11 August 2026

Re: State Significant Development Application No.SSD-82160220 (184 Fifth Avenue, Austral)

The Department of Education (the department) welcomes the opportunity to provide comments on the above State Significant Development Application (SSDA) and concurrent rezoning proposal (RP).

SHADOW DIAGRAM - 21 JUNE-10AM
SCALE: 1:1500@A1

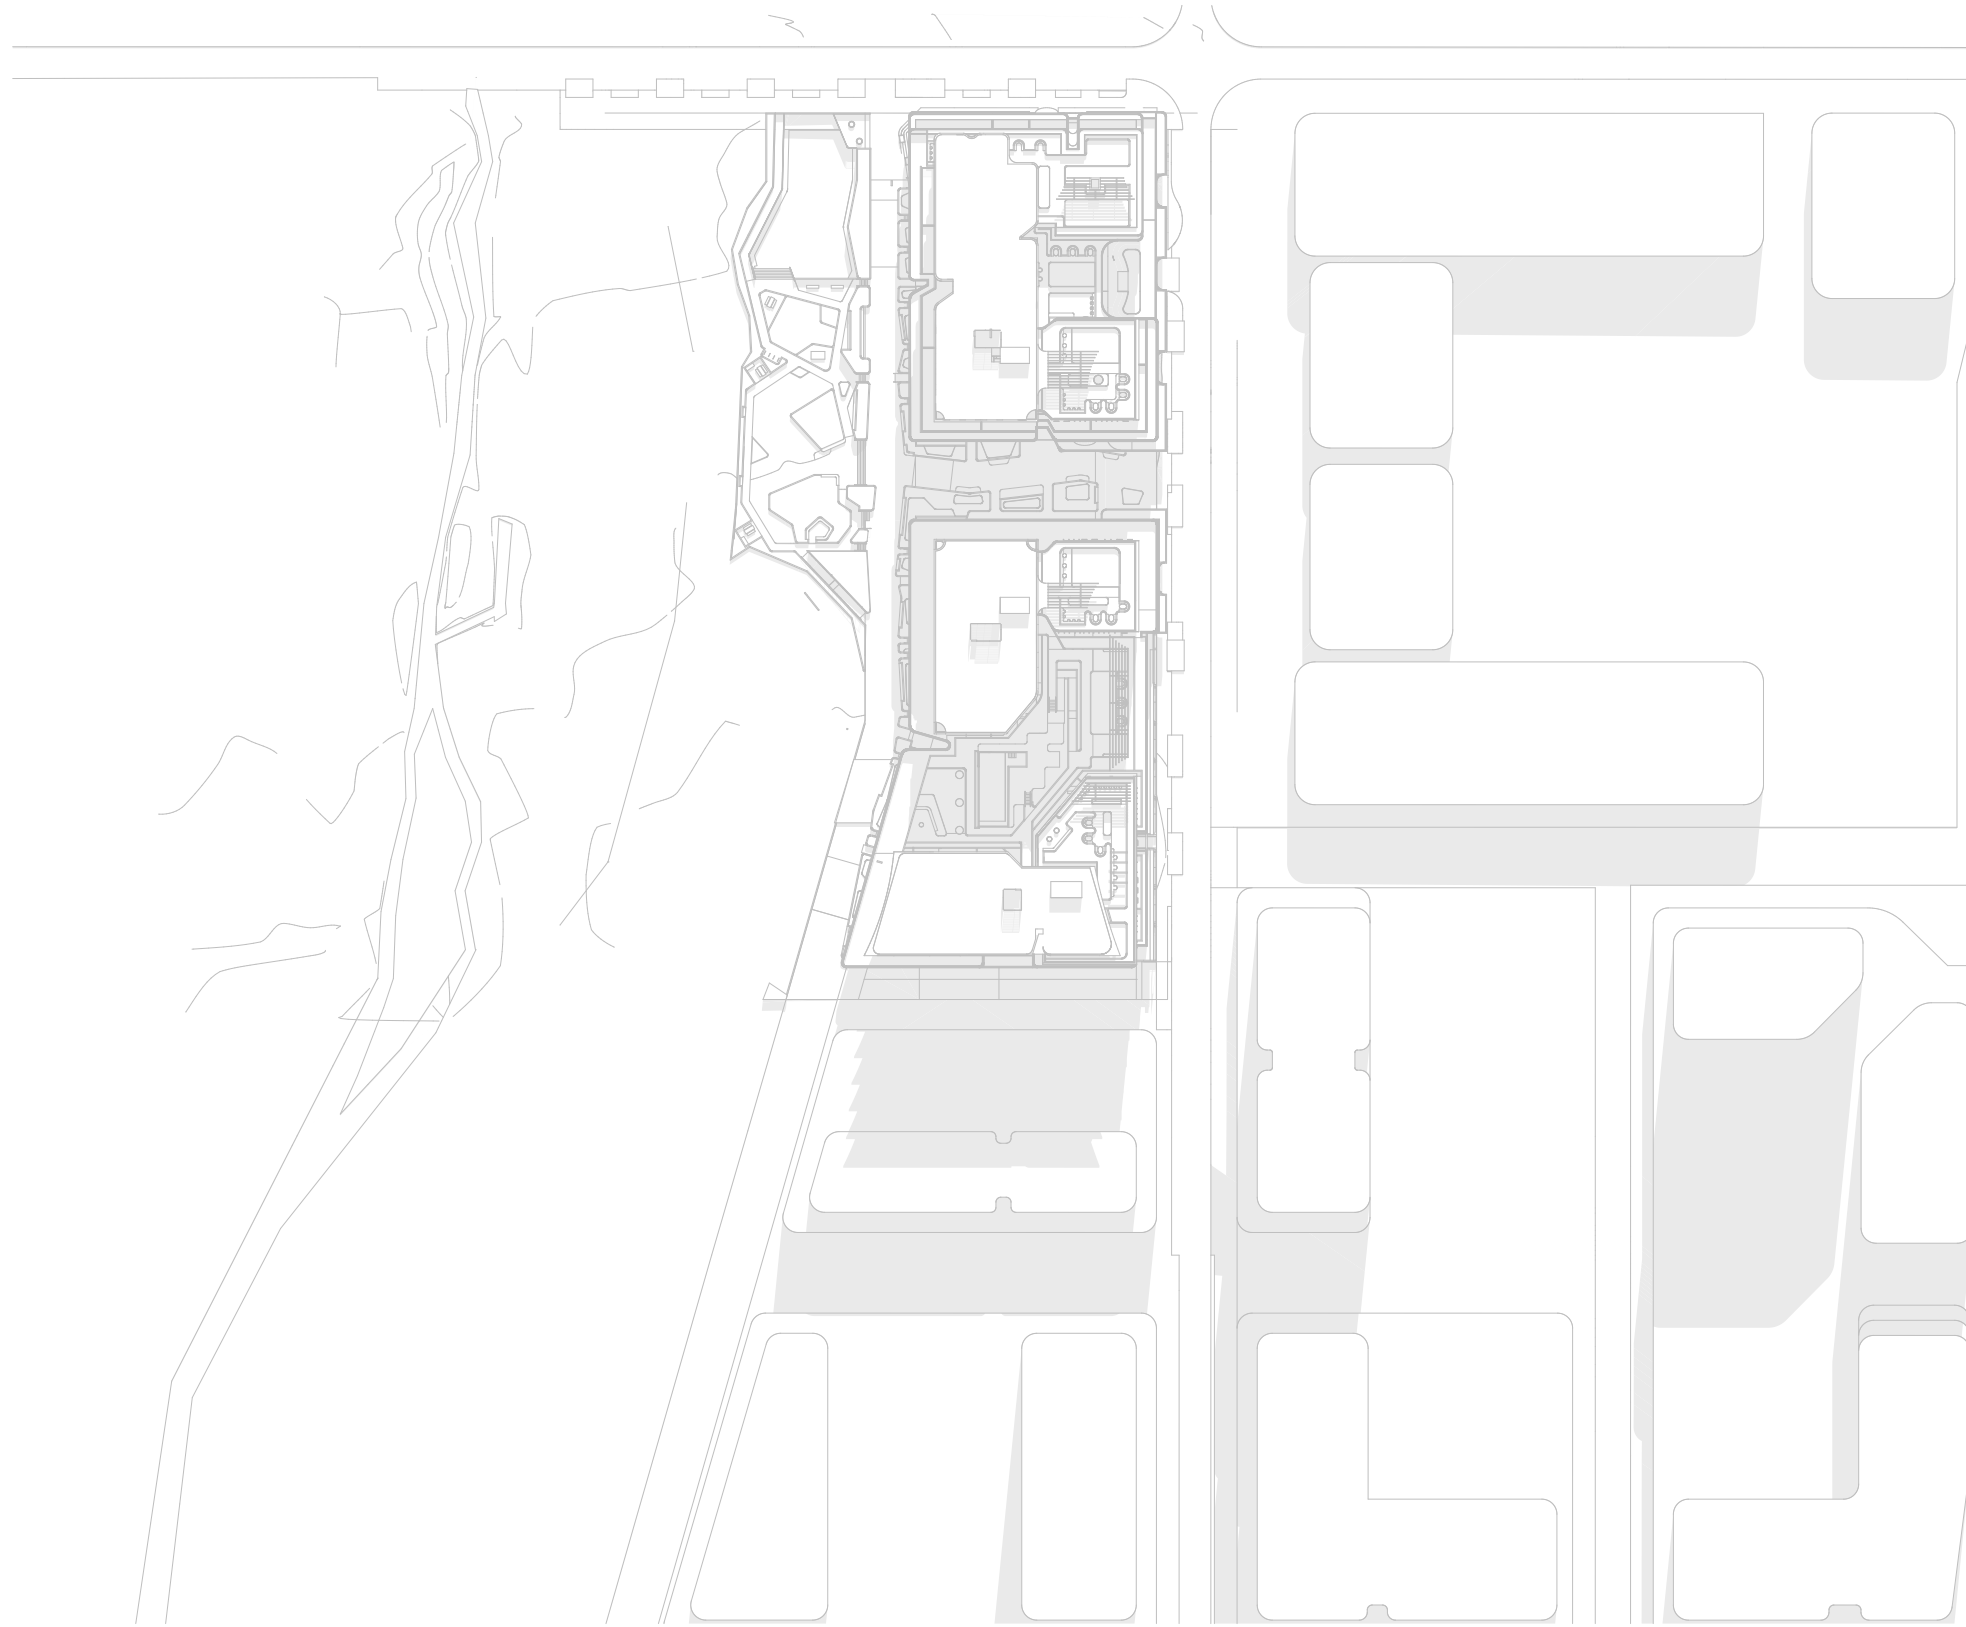
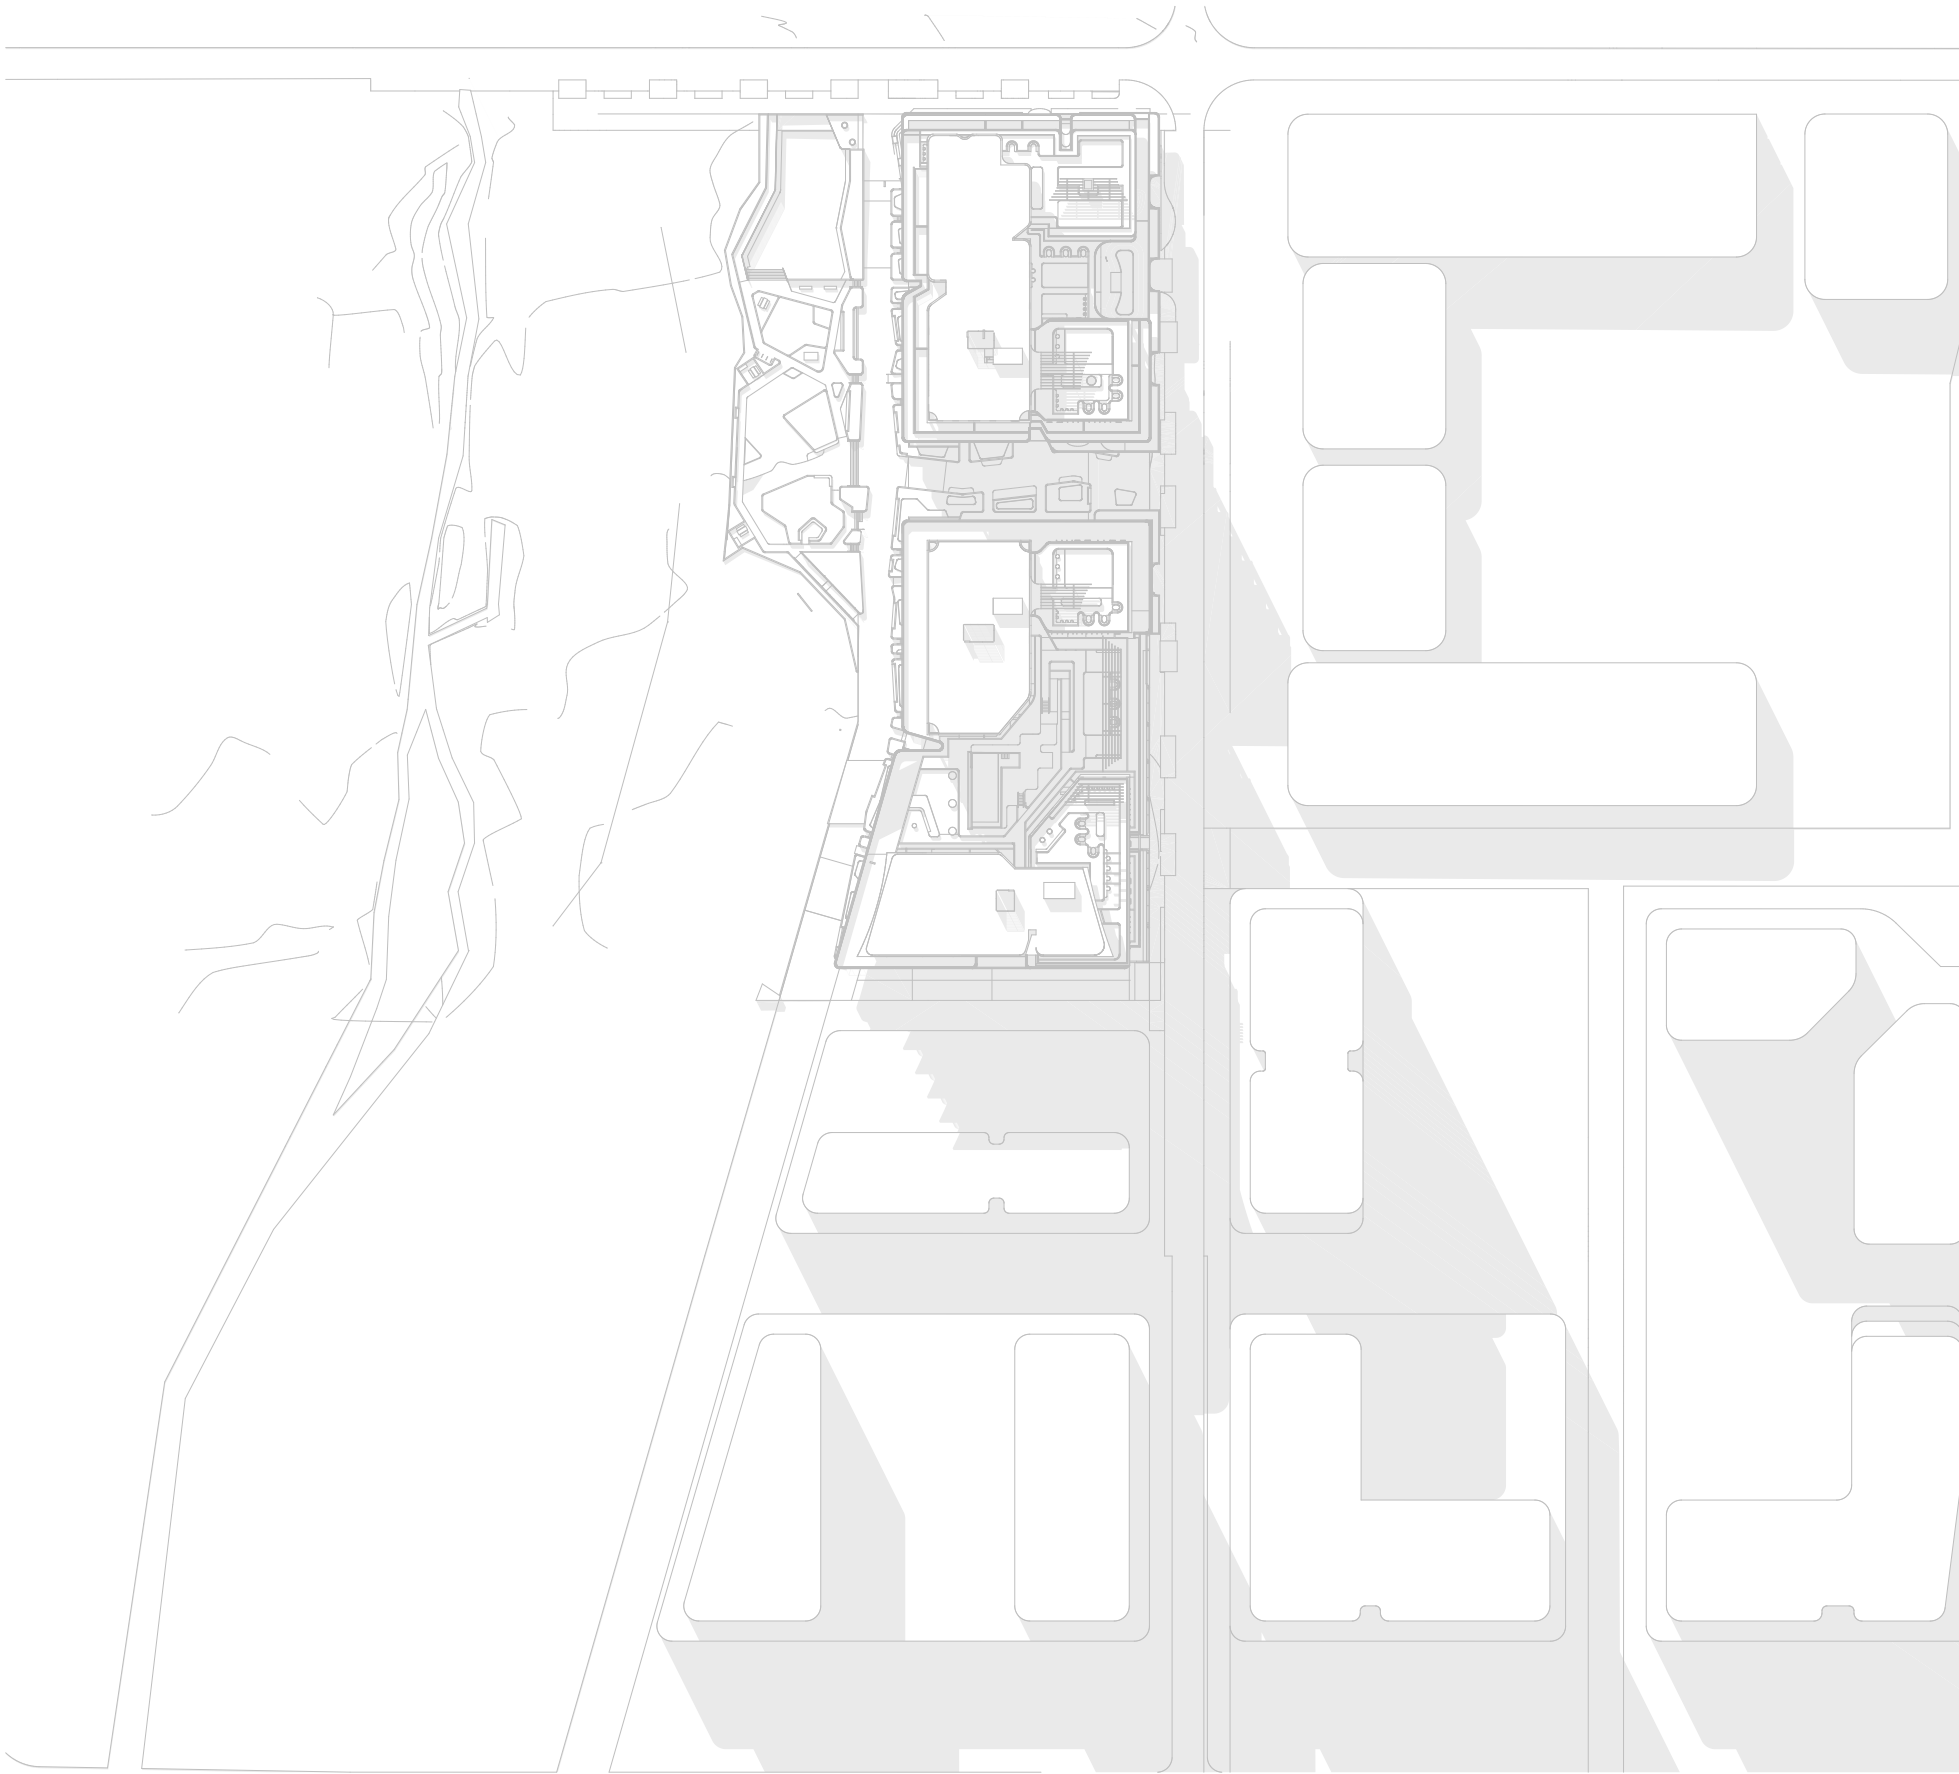
Overshadowing

The proposed development and rezoning propose significant up-lift in building height beyond that currently provided in Western Parkland City SEPP.

The siting and design of all proposed buildings should not have unreasonable overshadowing impacts on the proposed public school and public early learning facility. In particular, the development should ensure that the open play space areas and classroom buildings are not negatively impacted by overshadowing during school hours.
